### Pre-Application Meeting (PRE22-061)

<b>Site Location:</b>	7601 West Mercer Way	<b>Parcel Number</b>	936200-0030
<b>Lot Size:</b>	15,002 square feet	<b>Zoning:</b>	R-15 (Single Family)
<b>Brief Project Description:</b>	A proposal to repair an existing pier and replace an existing, wood bulkhead and stairs with a rock bulkhead.	<b>Documents Provided:</b>	1. Pre-Application Meeting Request Form 2. Plan Set 3. Project Narrative 4. List of Questions 5. SEPA Checklist
<b>Applicant Information:</b>			
<b>Name:</b>	Dray Davick (Seaborn Pile Driving)	<b>Email:</b>	<a href="mailto:permits@seabornpiledriving.com">permits@seabornpiledriving.com</a>
<b>Phone:</b>			206-236-1700
<b>Second Pre-application Meeting Required:</b>	Not Applicable	<a href="#">Click for explanation if necessary</a>

October 13, 2022

EXISTING CONDITIONS

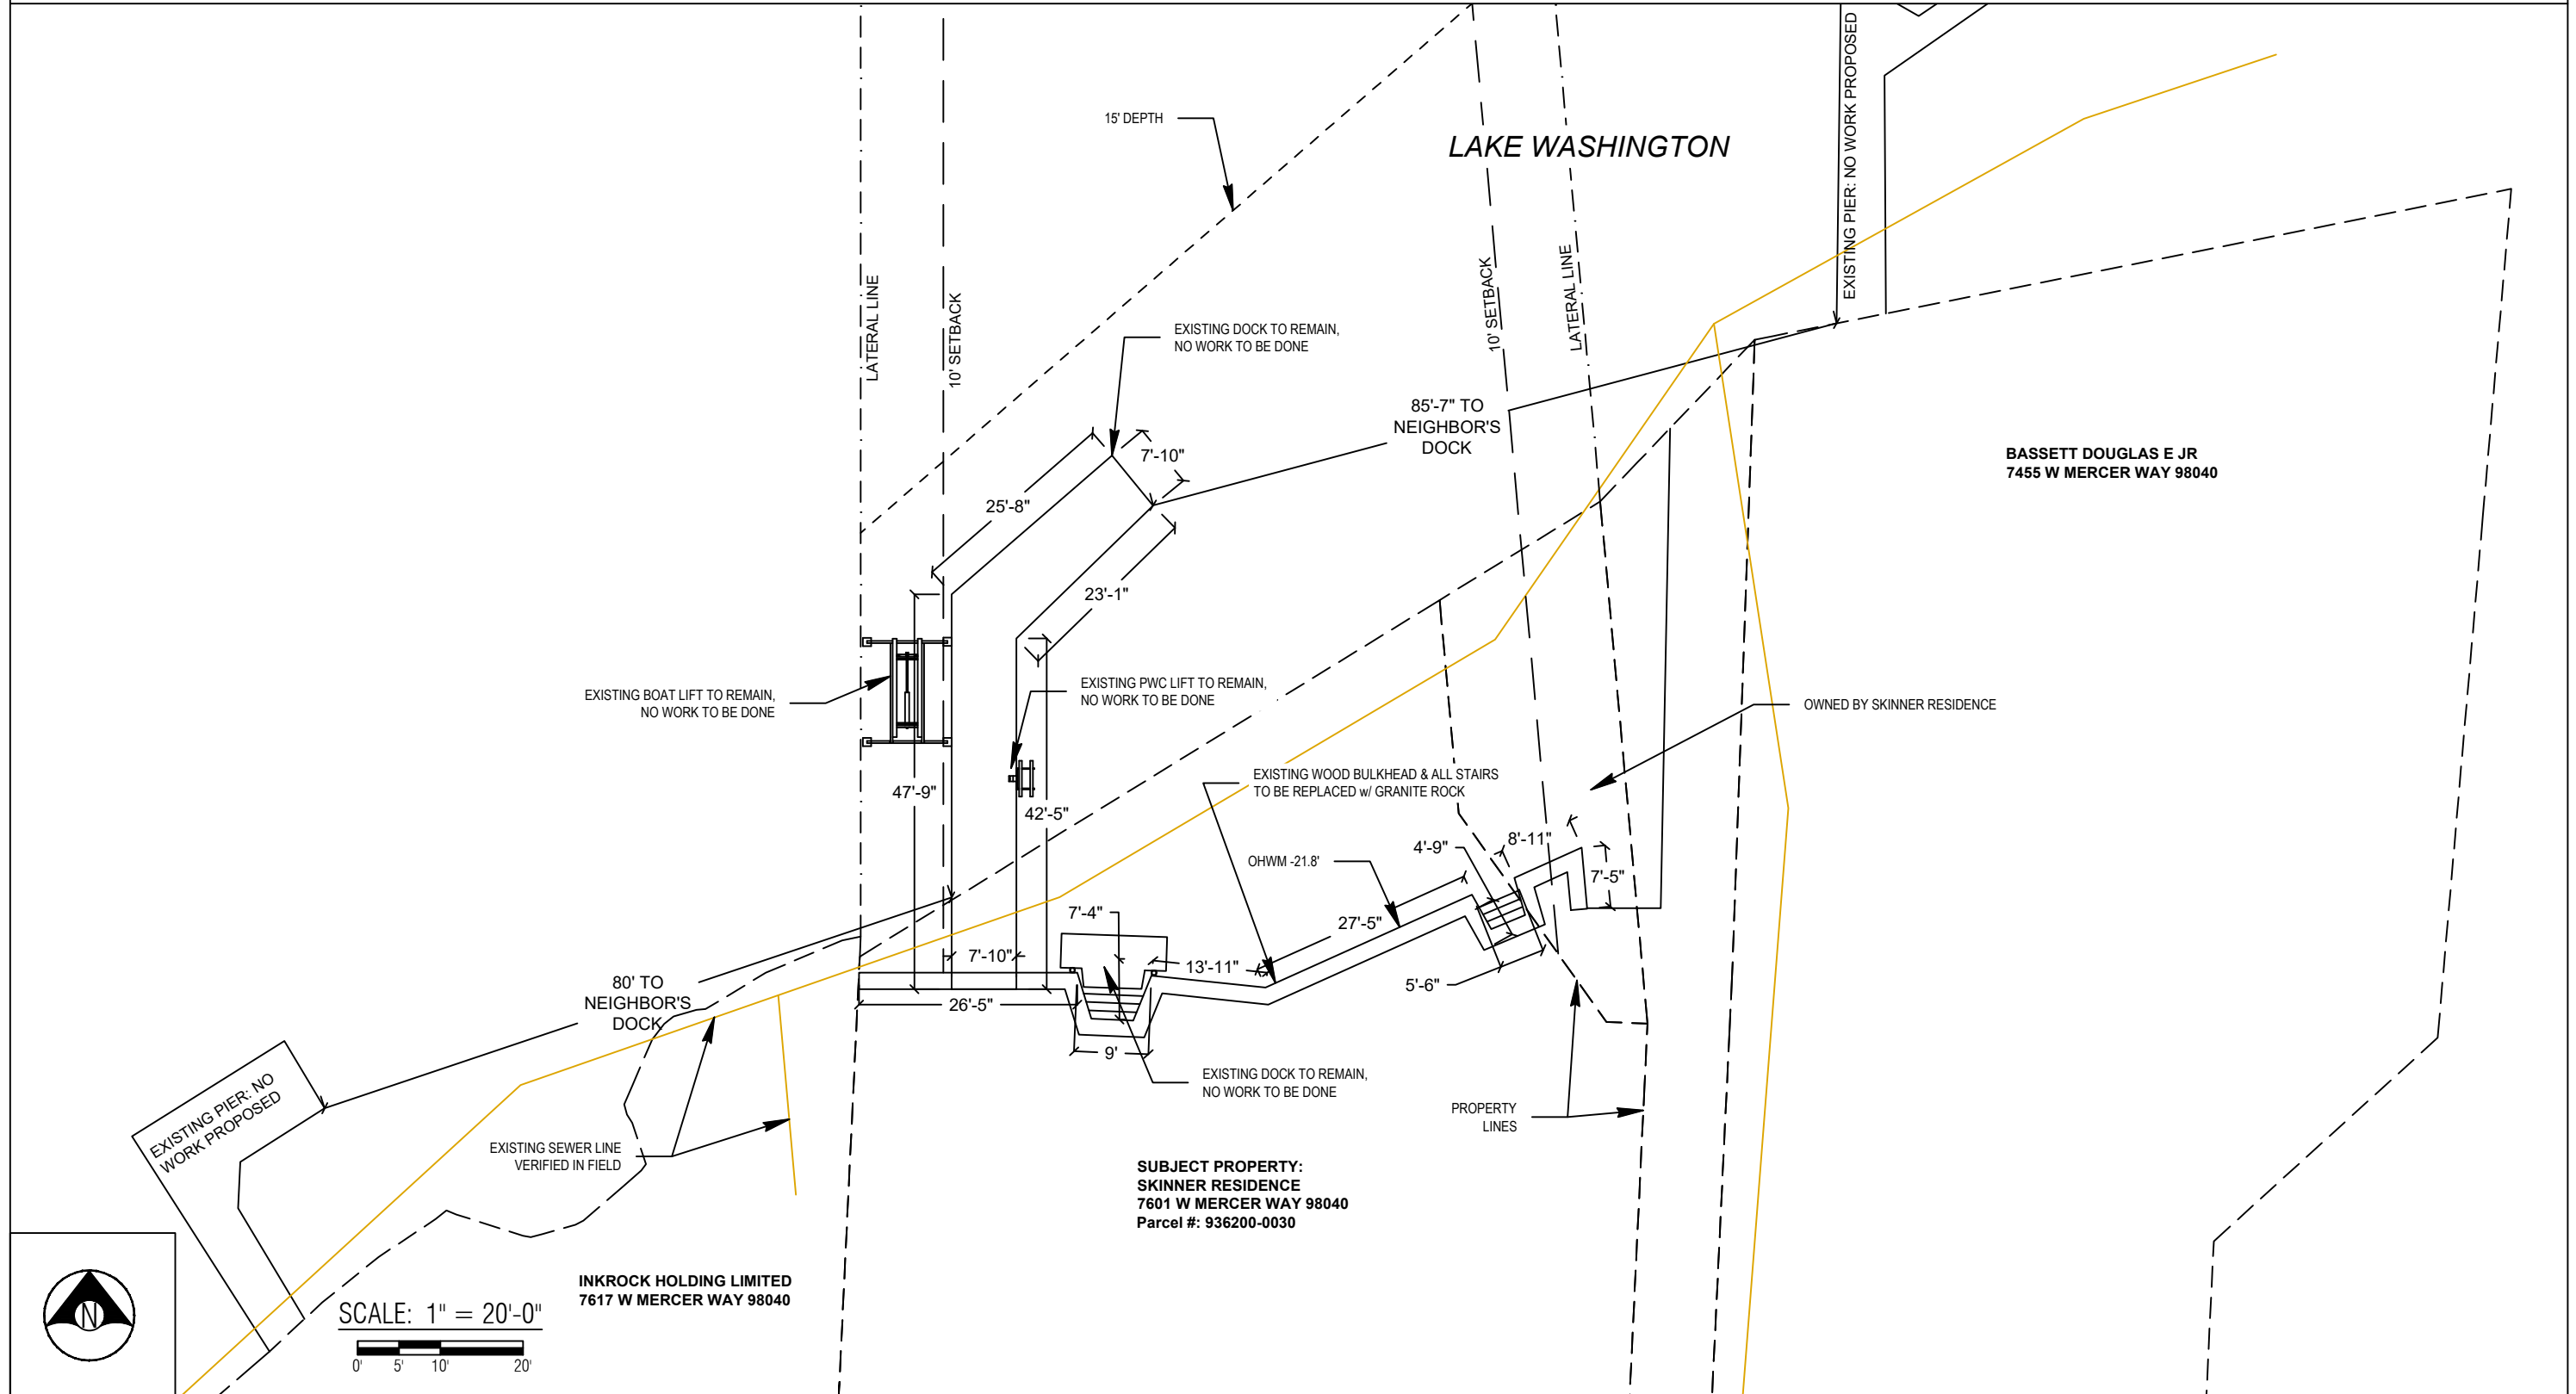
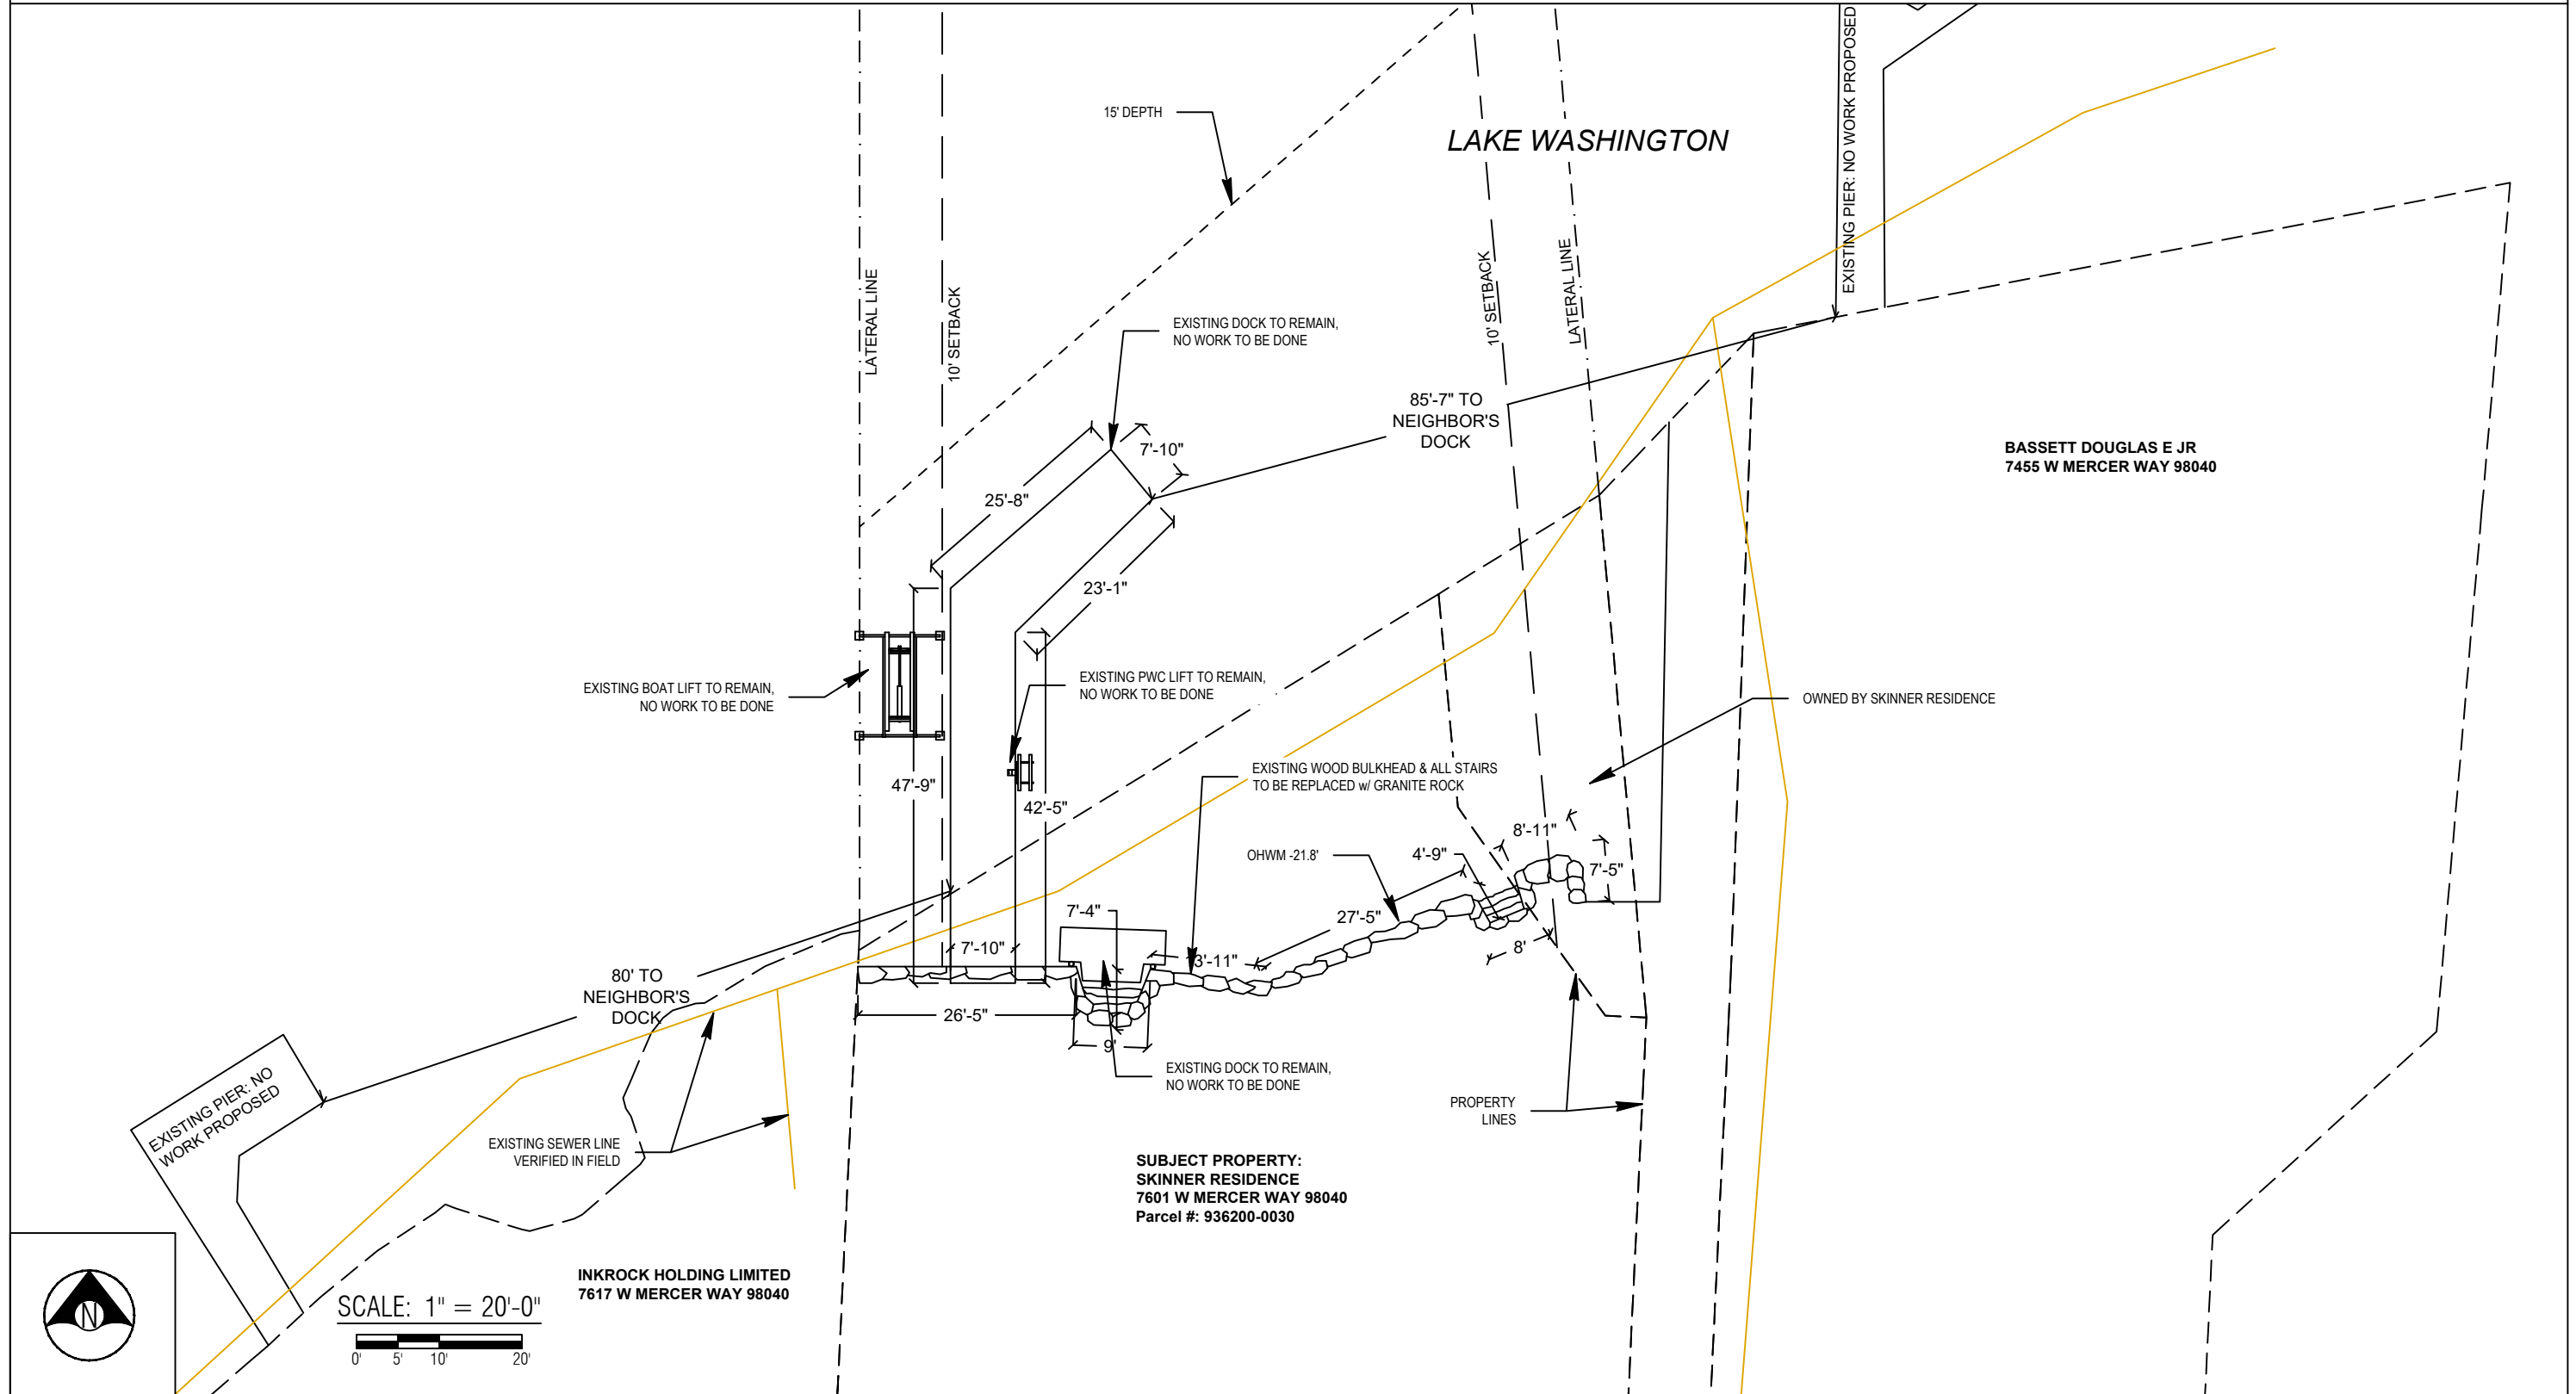
- a. This project will require SEPA review since it includes work on lands covered by water.
- 3. Non-conforming issues / items
  - a. This site contains two piers. MICC 19.13.050(D) states that only one noncommercial, residential moorage facility per upland lot is authorized.

- b. One existing boat lift is located within the 10-foot lateral line setback from the south lateral line.
  - c. MICC 19.13.020(A) states that overwater uses and structures, and uses and structures 25 feet landward from the OHWM, which were legally created may be maintained, repaired, renovated, remodeled, and completely replaced to the extent that nonconformance with the standards and regulations of the city's Shoreline Master Program is not increased.
